From: Laura Gibbons <Laura.Gibbons@arun.gov.uk>
Sent: 05 April 2022 11:13
To: Planning.Responses <Planning.Responses@arun.gov.uk>
Cc: David Easton <David.Easton@arun.gov.uk>
Subject: RE: Planning Consultation on: Y/33/22/DOC

Engineers Comments Regarding Condition 9

Description of Works: Approval of details reserved by condition imposed under ref Y/91/17/OUT relating to Condition No 9 - surface water drainage.

BASIN 1 SECTION A-A
SCALE: H 1:500,V 1:100. DATUM: 2.000

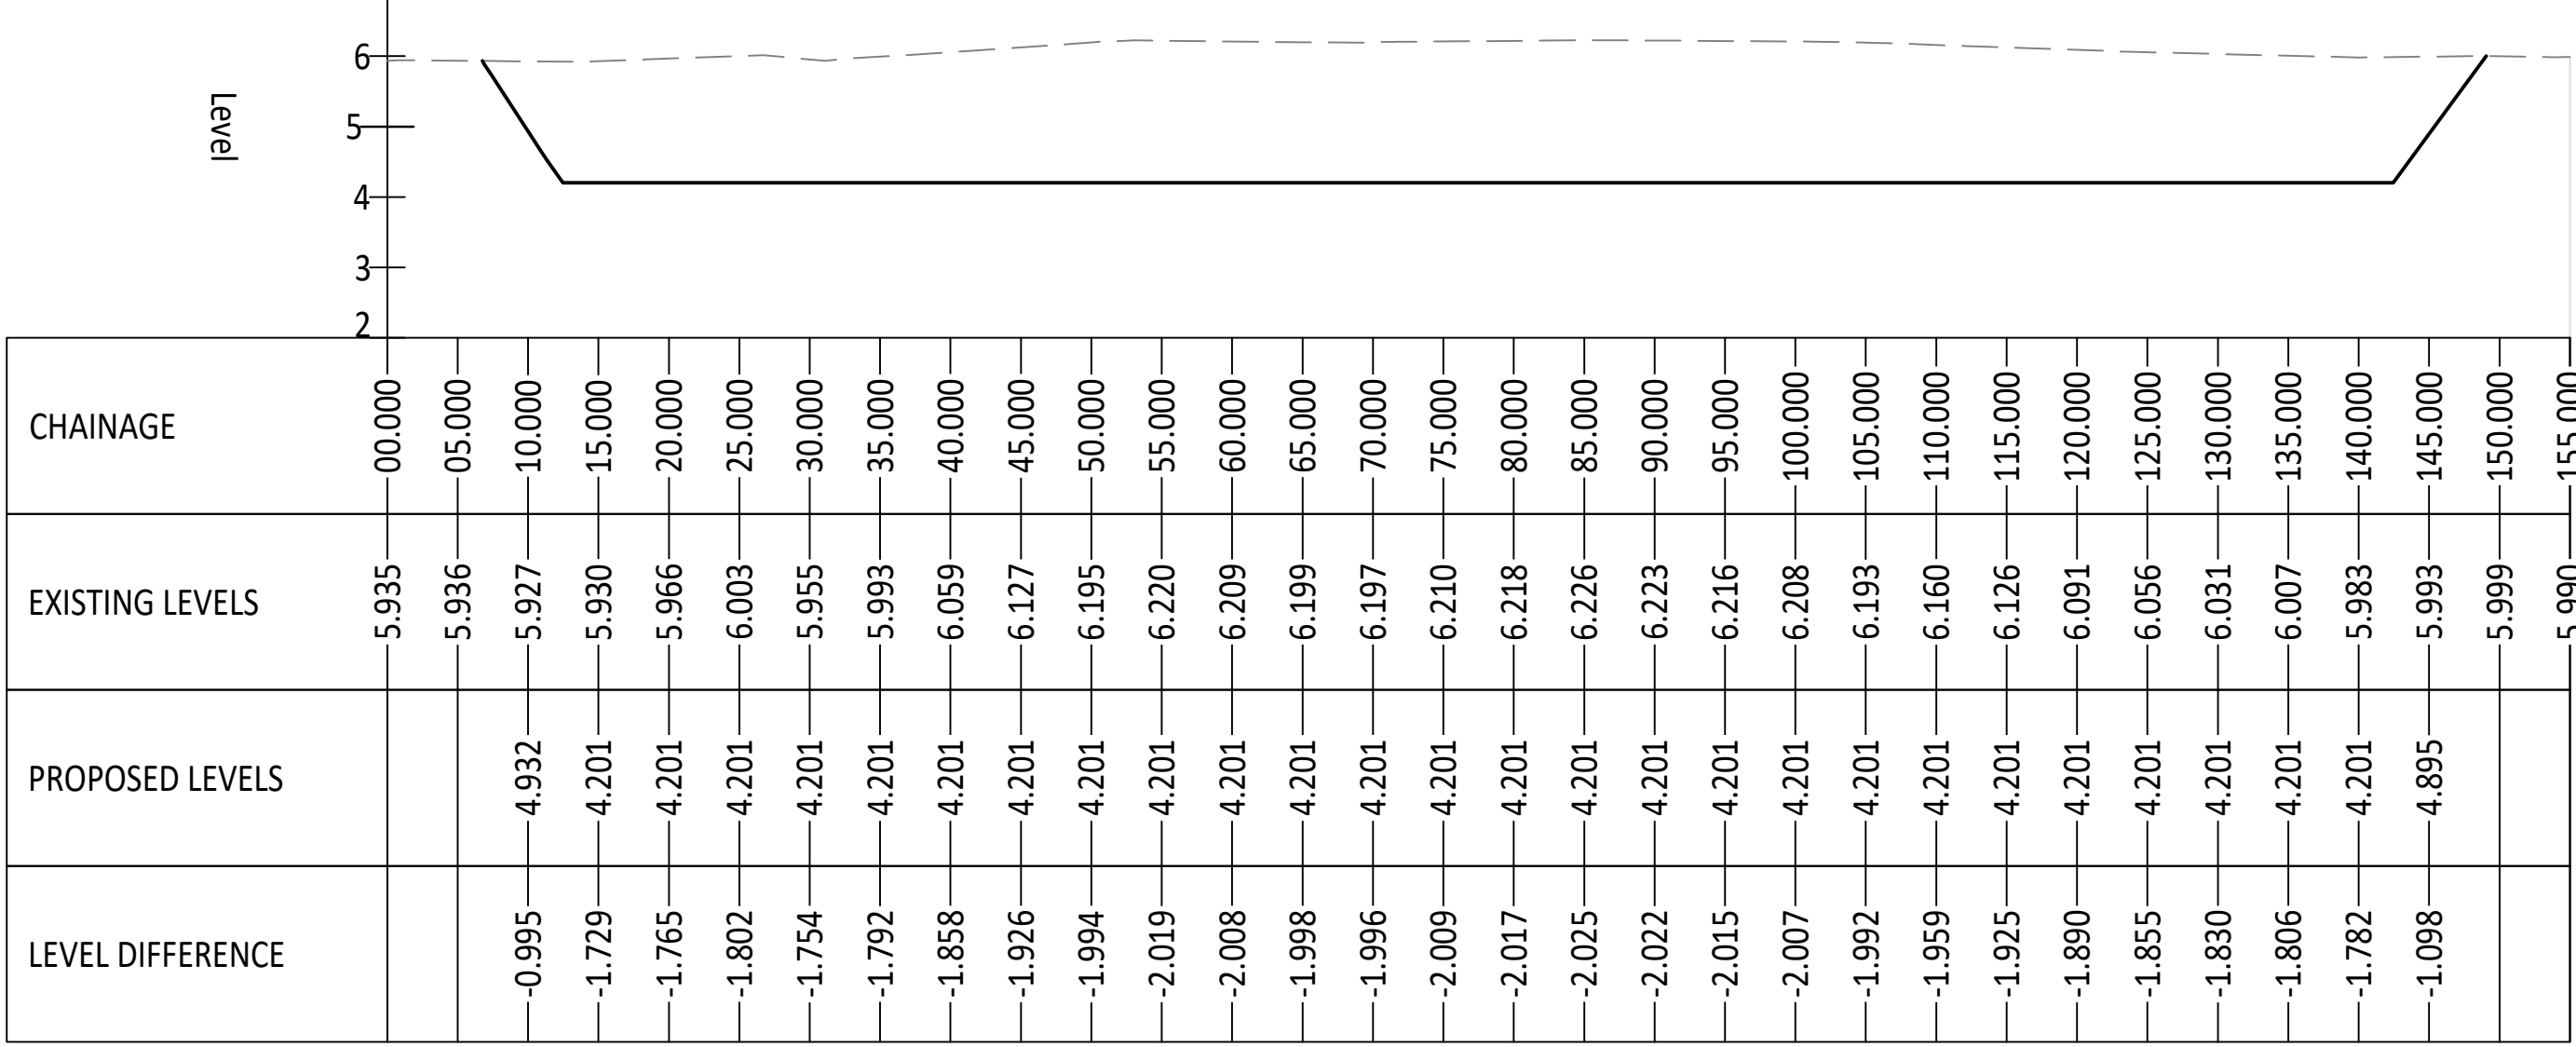
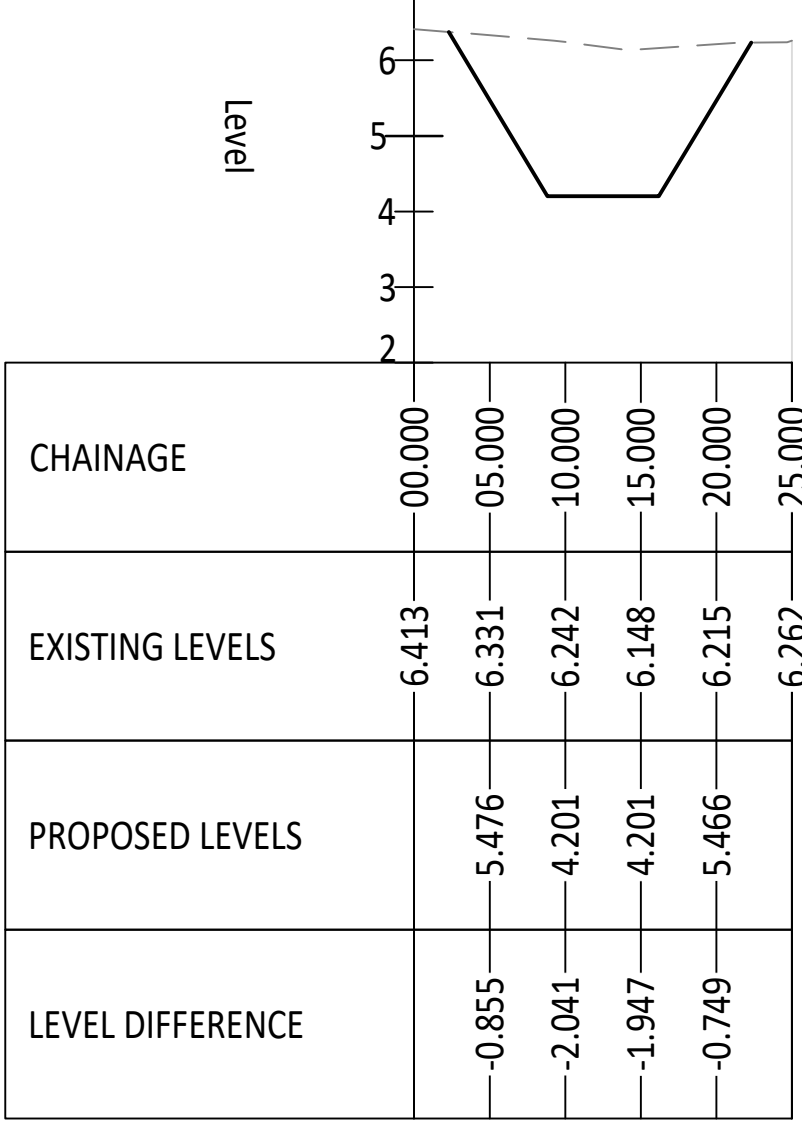
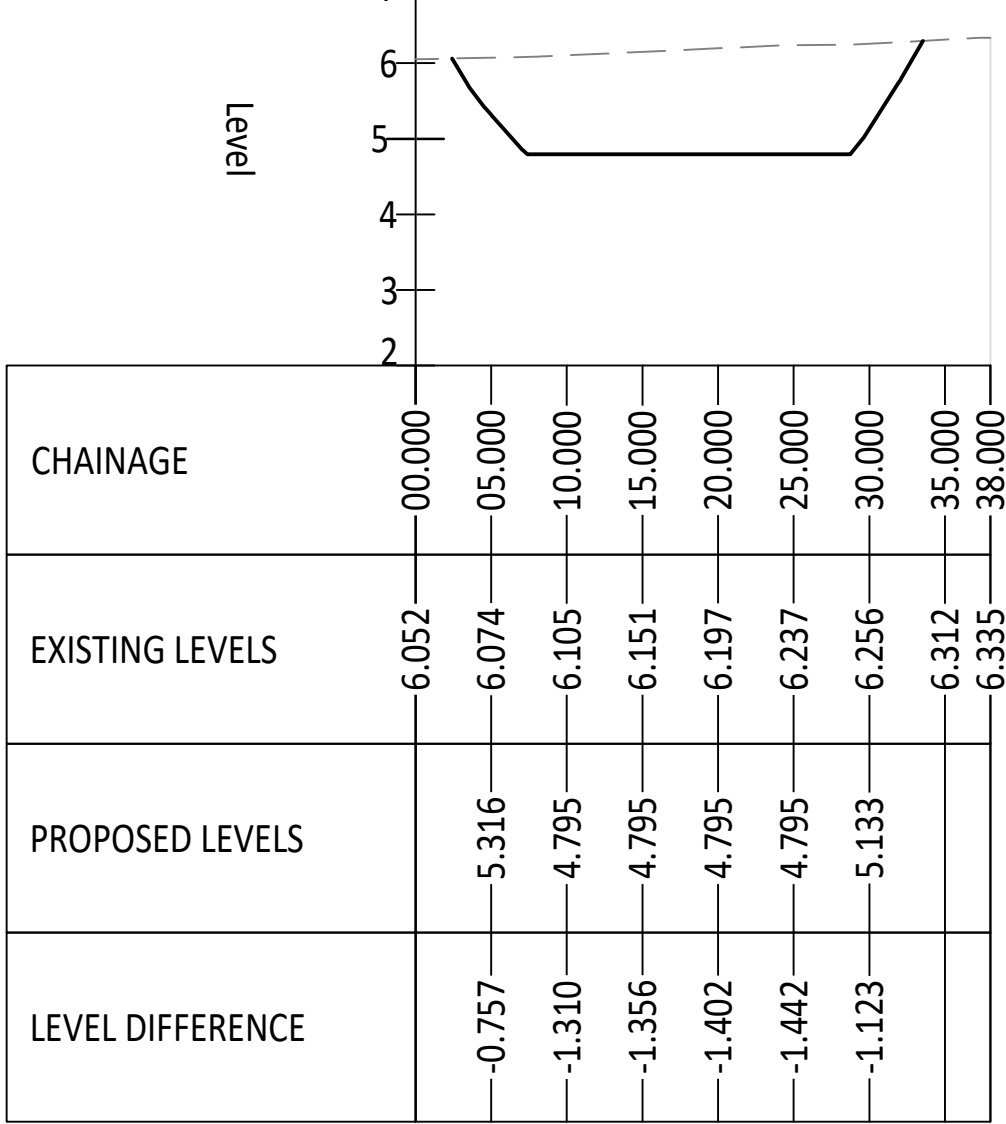
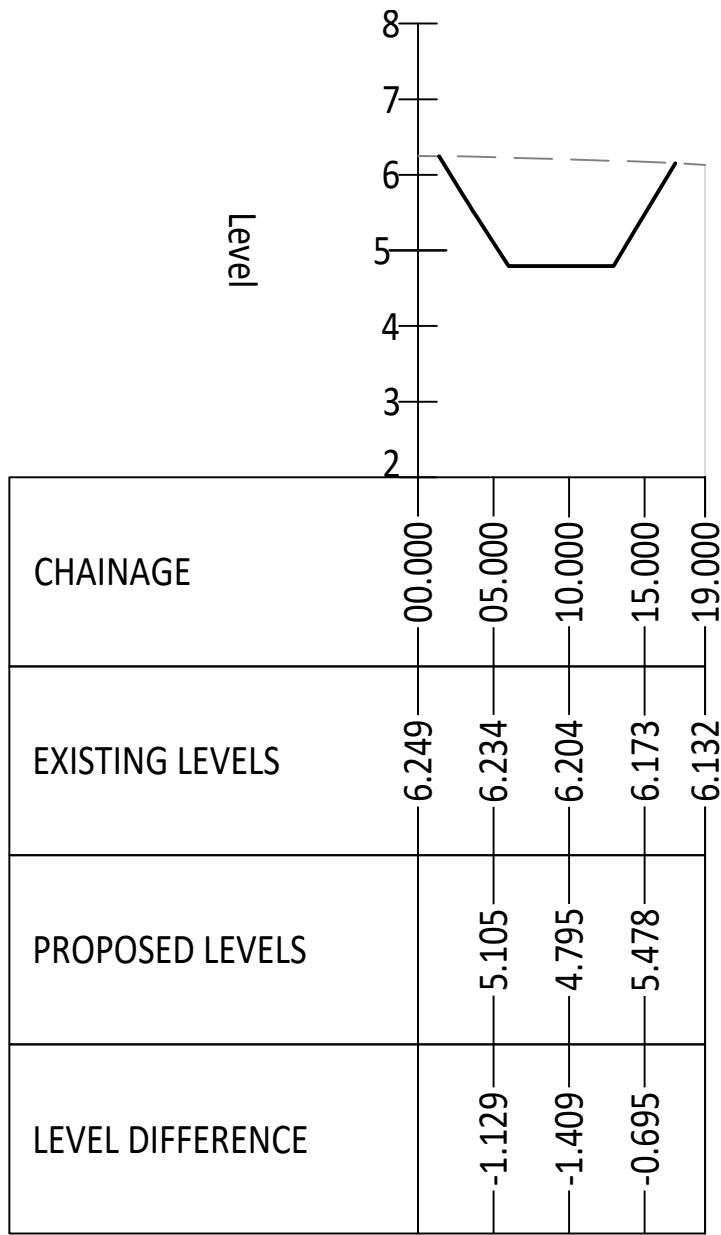
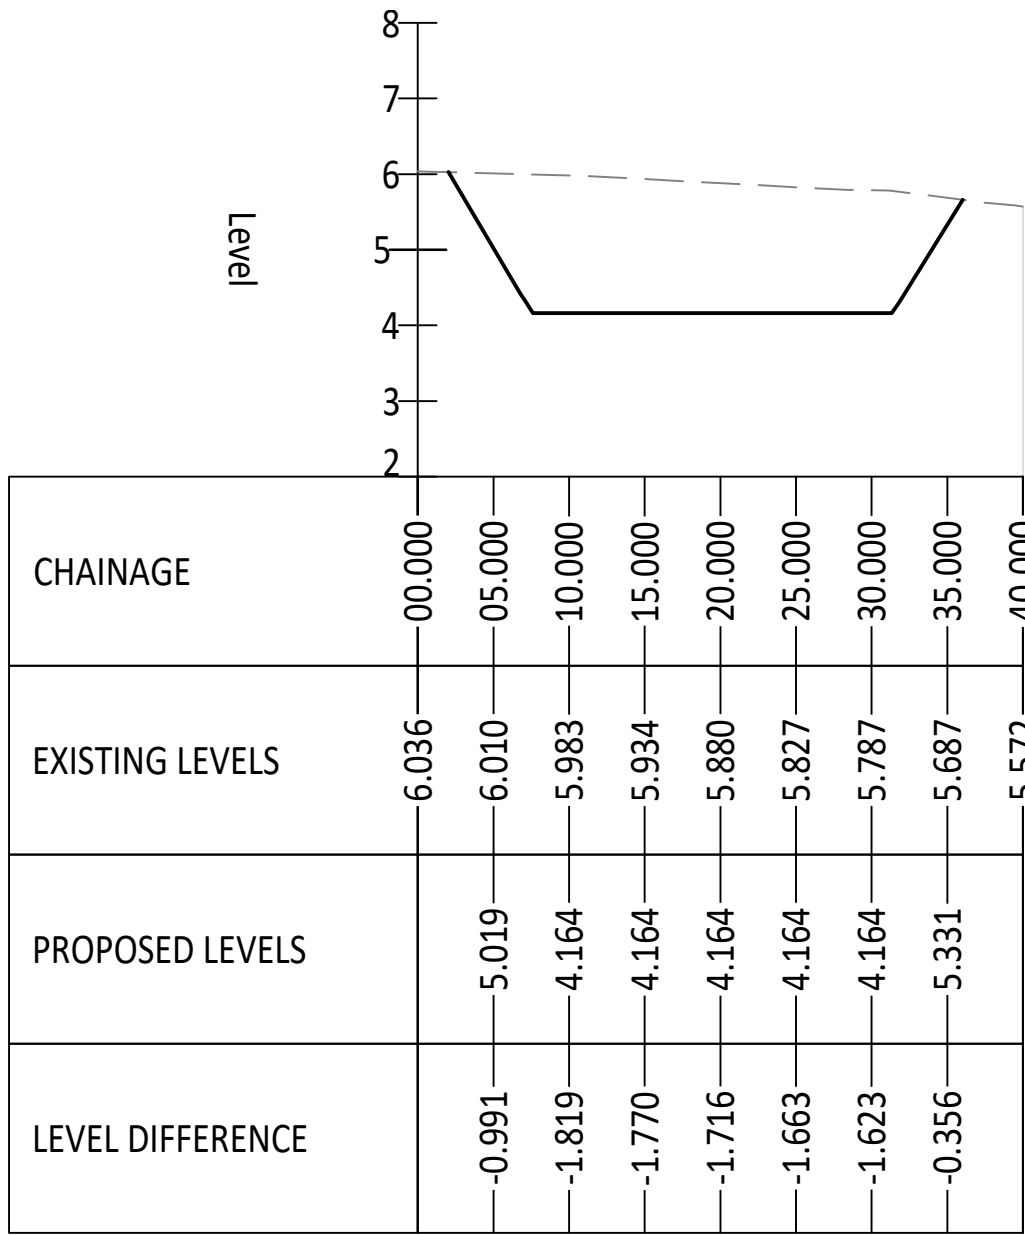
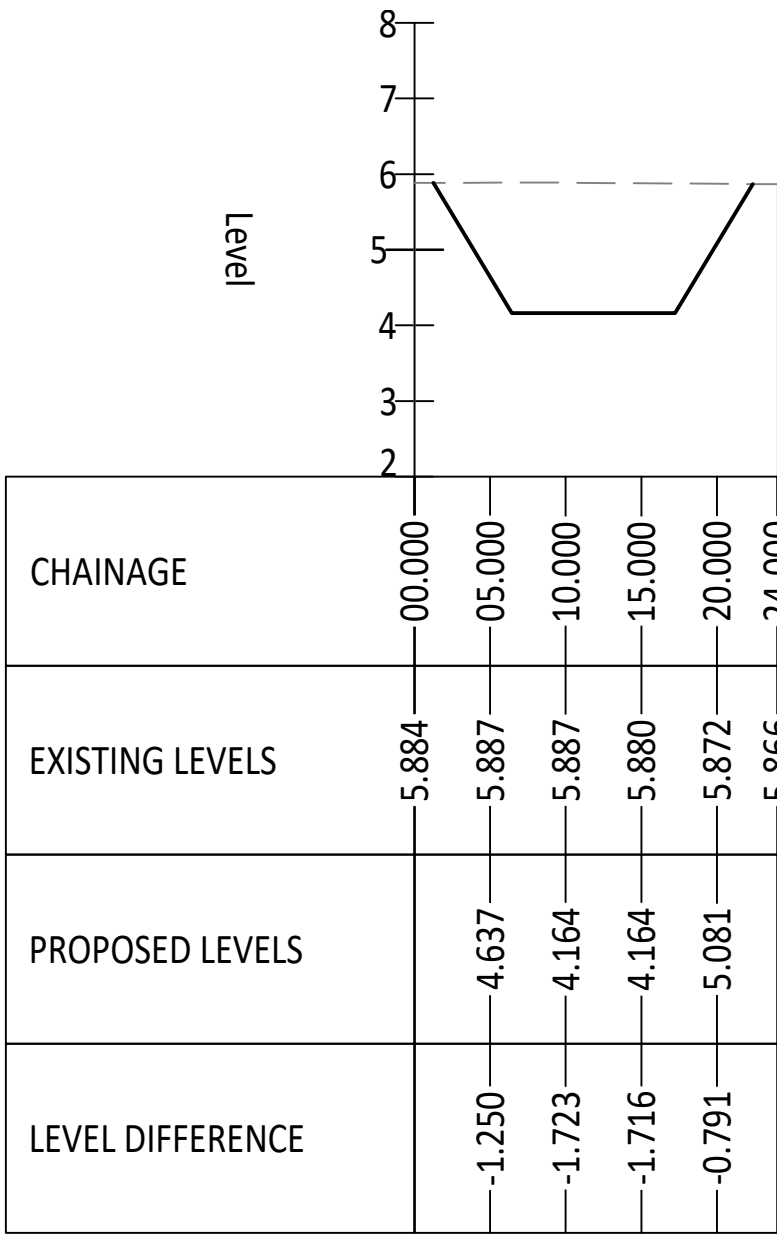
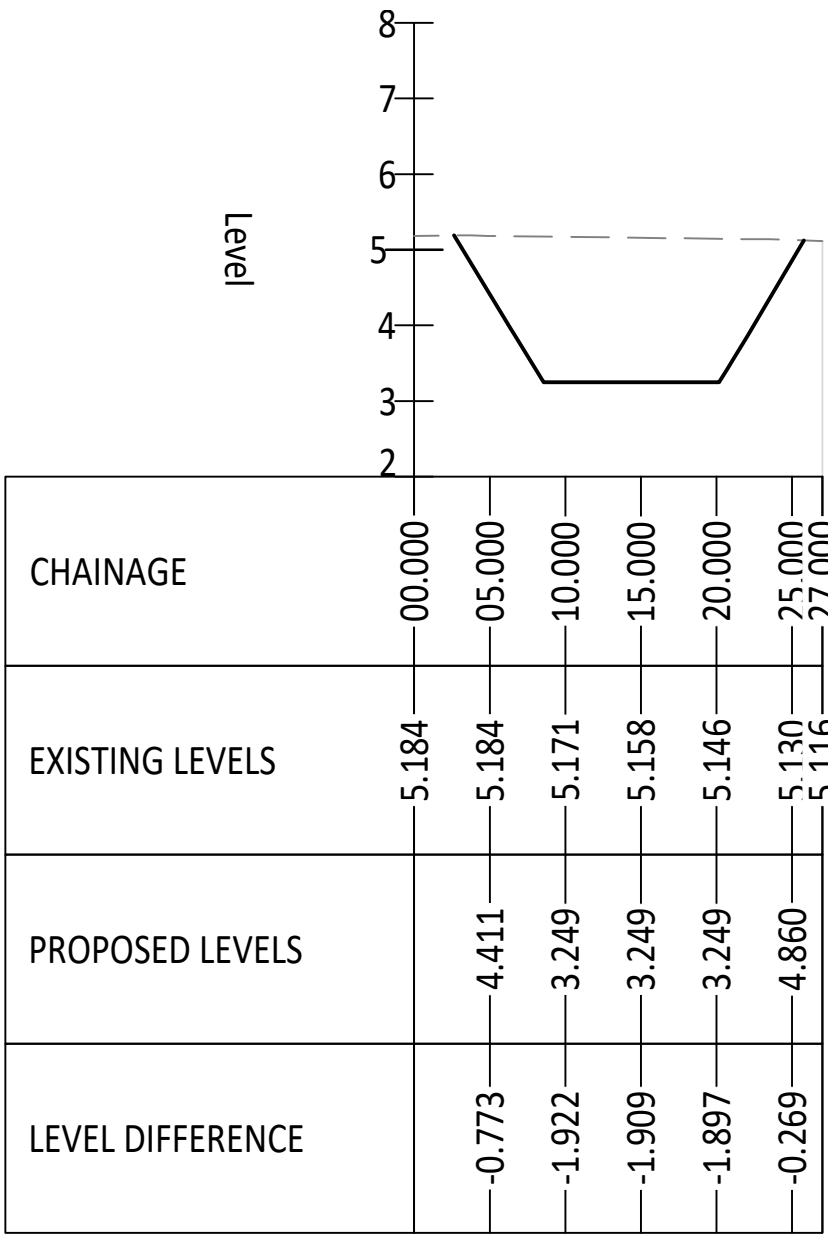
24. Please provide construction detail drawings of basins which clearly show required depths of topsoil and clay over liner which tally with flotation calculations. These details should show invert level, peak water level, and top of bank level of each basin, along with bank slope. Two perpendicular details per basin should be provided.
